**Subject: Request for advice on EIS - Pymble Ladies' College Secondary Innovation Precinct (SSD-79146716) (Ku-ring-gai)**

**CPHR response on the EIS for Pymble Ladies' College Secondary Innovation Precinct  
SSD -79146716**

Figure 5 Local site topography

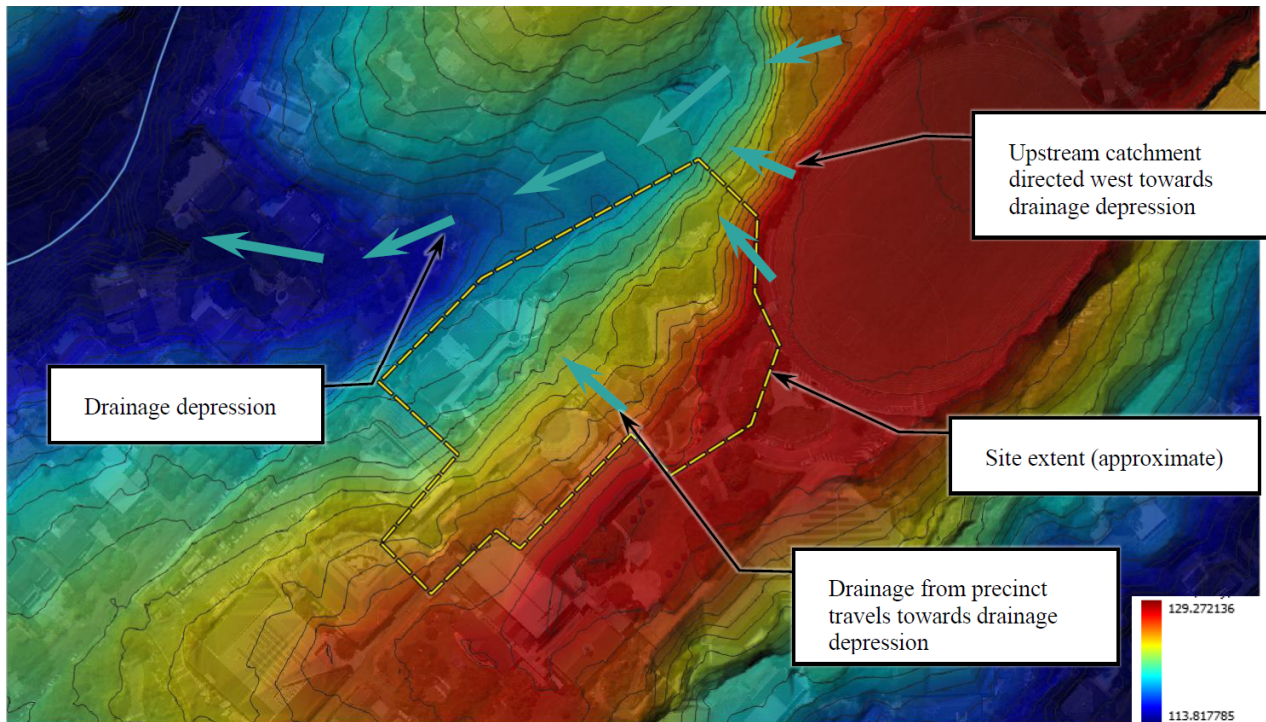
- Appendix C of the WMP includes a Flooding Assessment prepared by ARUP dated 3 March 2025.
- The site is not identified as flood prone land. The development footprint is in the upstream area of Avondale Creek catchment and adjacent to a minor tributary.
- The runoff from the small area upstream of the site is less than 20 m<sup>3</sup>/s as identified in the WMP.
- Therefore, the habitable floor should be identified in accordance with clause 3 of the Ku-ring-gai DCP Section 24D.3. Table 3 of the flood assessment should reflect this clause.
- No further flood risk management input is required.
